Date: 02/18/2025

Re: **Framing Item**
Location: Lot 70 Wellers Knoll (Blanton Court Lillington, NC)
JDS Project No.: RDU2501570
Date of Inspection: 02/17/2025

OPTIONAL 3RD FLOOR
(SHOWN WITH ELEVATION A - ALL OTHER ELEVATIONS SIMILAR)

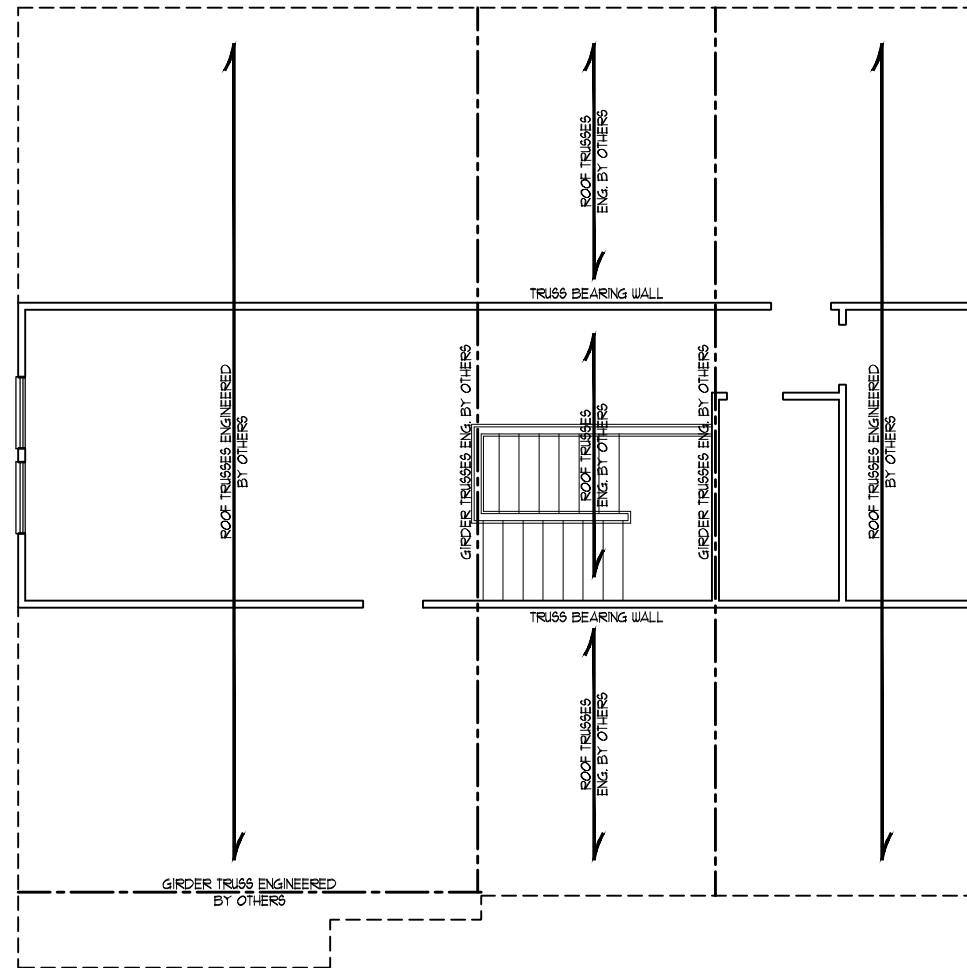
Below the 3rd floor bathroom the carrying header at the front of the field framed floor joist has been over notched and abandoned by HVAC. The header carrying (1) 3rd floor 13 1/2' 2x10 floor joist and 2nd floor ceiling joist cannot be repaired.

Based on our onsite observations and review, temporarily remove the plumbing waste line penetrating the current header to allow replacement with a new (1) 2x10 header attached to the adjacent bottom chords with facemount 2x10 joist hangers on each end. Then, the waste line may be re-connected.
